Addendum No. 1

RE: Contract ID: C202473
WBS# 45066.3.ST2
F.A. # STM-000S(594)
Buncombe County (B-5179B)
I-240 Bridge Deck Preservation

December 15, 2009 Letting

**TRAFFIC CONTROL PHASING
AREA 3 AND AREA 4**

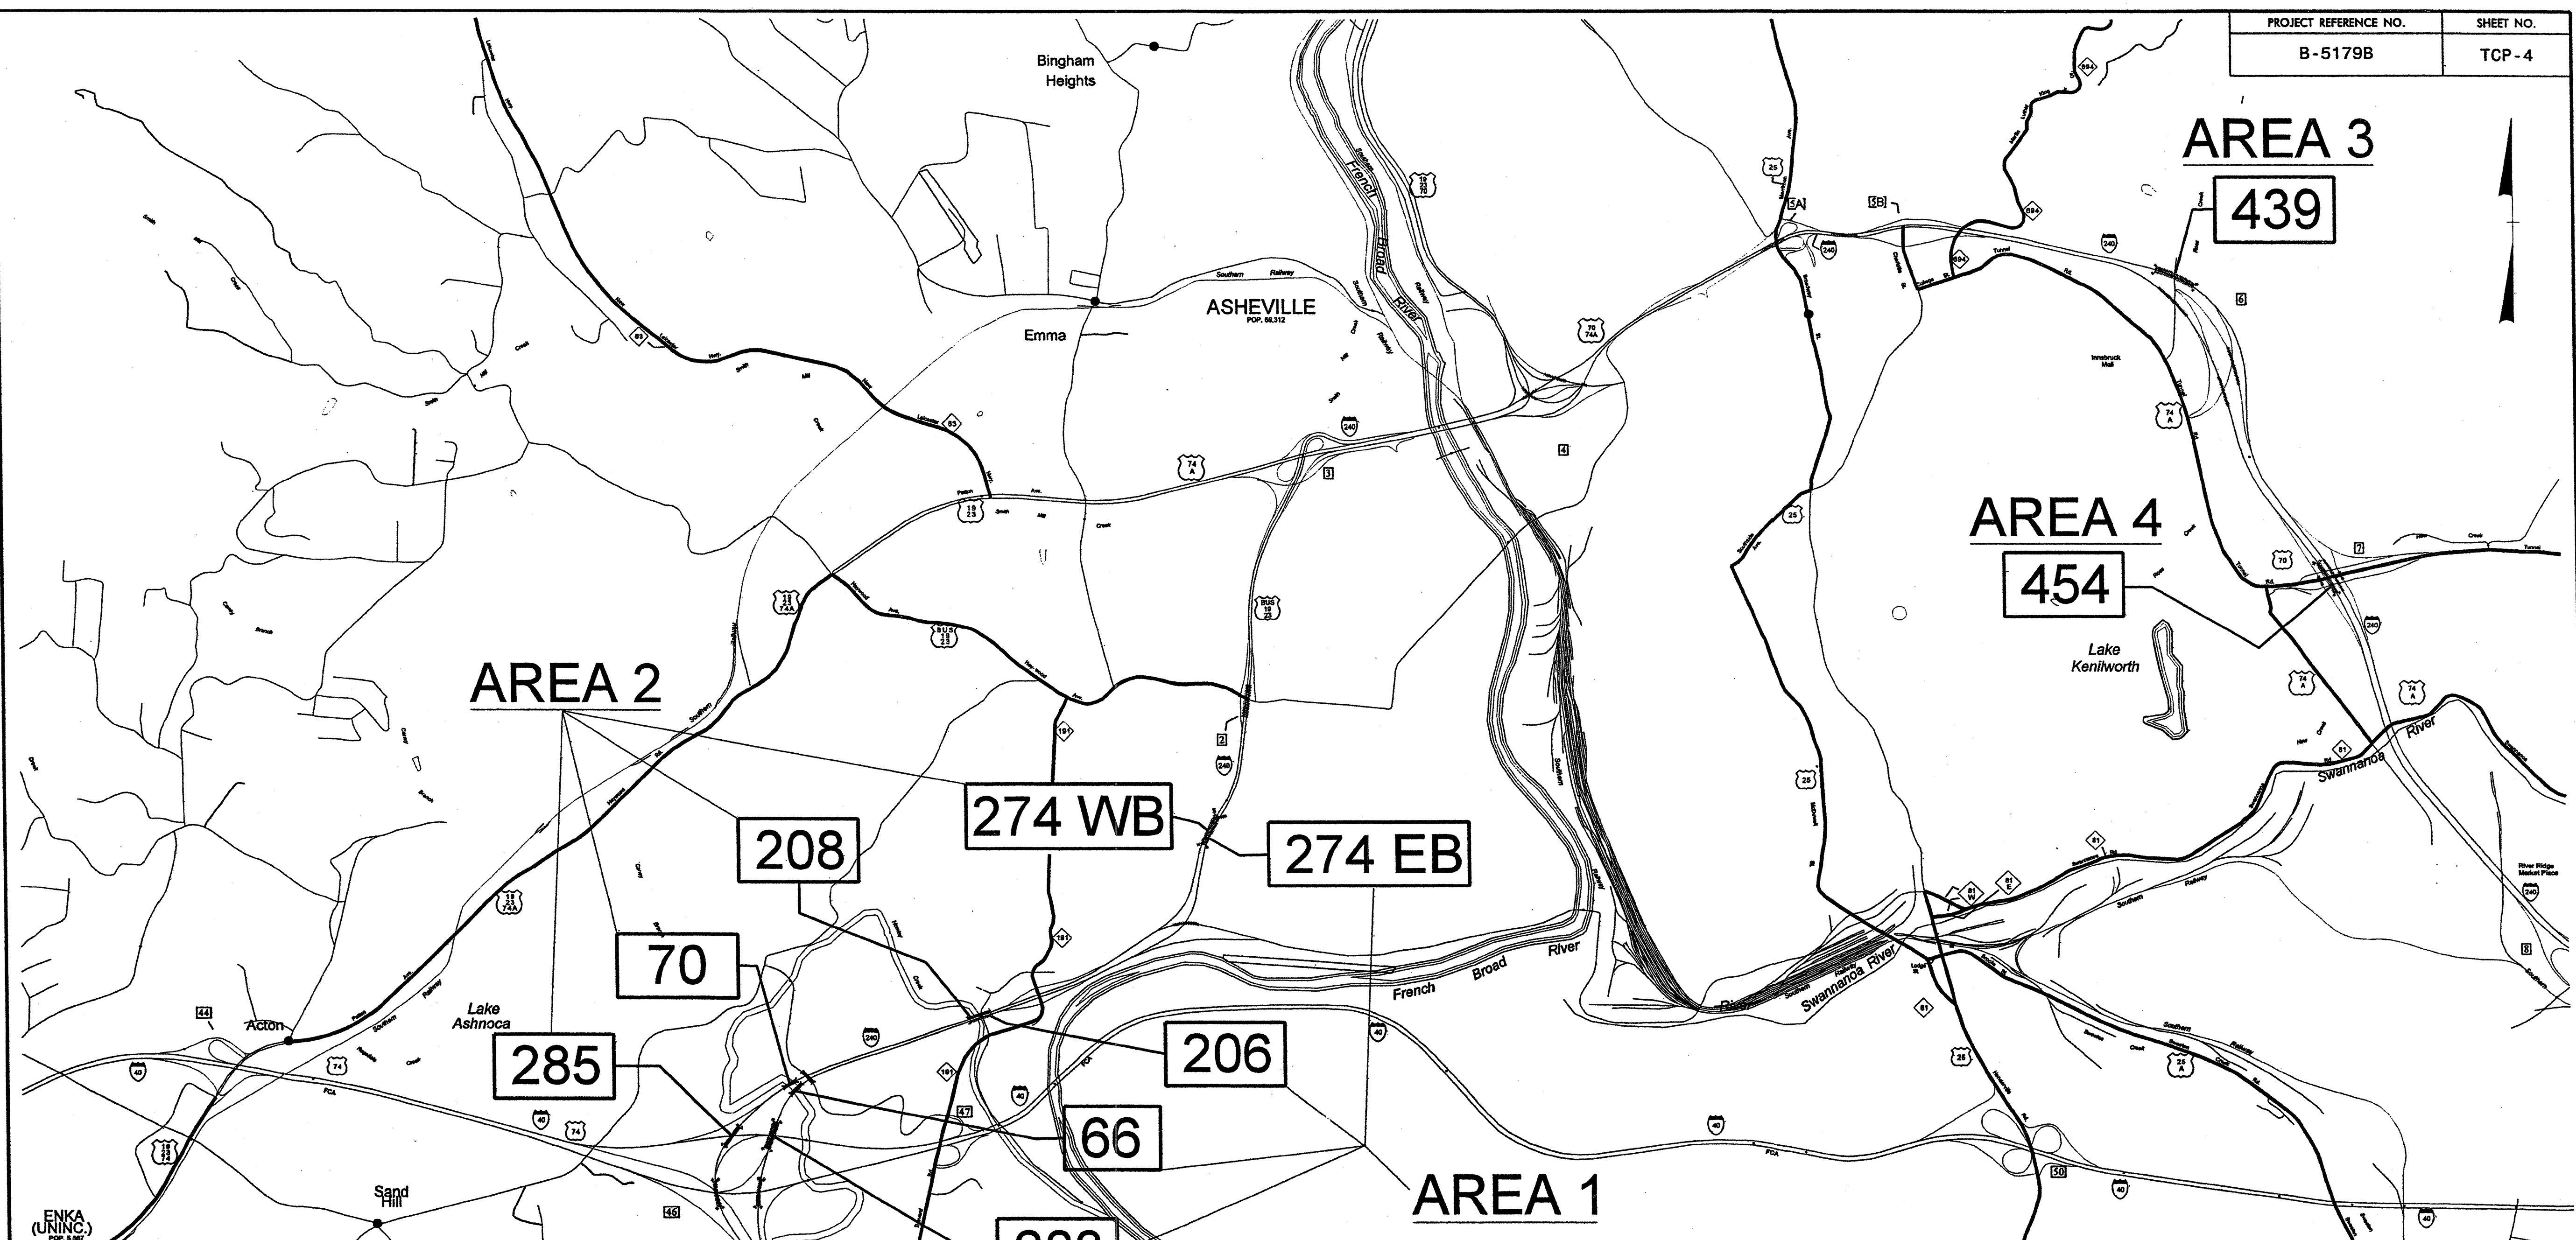
Sheet No. TCP-3A has been revised to agree with the above noted revised Intermediate Contract Times. Please void Sheet No. TCP-3A in your plans and staple the revised Sheet No. TCP 3-A thereto.

The Contractor shall complete the work required of **Area 3, Steps 1 to 7** as described on Sheet **TCP-3A** and shall place and maintain traffic on same.

The Contractor shall complete the work required of **Area 3, Steps 8 to 14** as described on Sheet **TCP-3A** and shall place and maintain traffic on same.

The Contractor shall complete the work required of **Area 4, Steps 1 to 7** as described on Sheet **TCP-3A** and shall place and maintain traffic on same.

The Contractor shall complete the work required of **Area 4, Steps 8 to 14** as described on Sheet **TCP-3A** and shall place and maintain traffic on same.
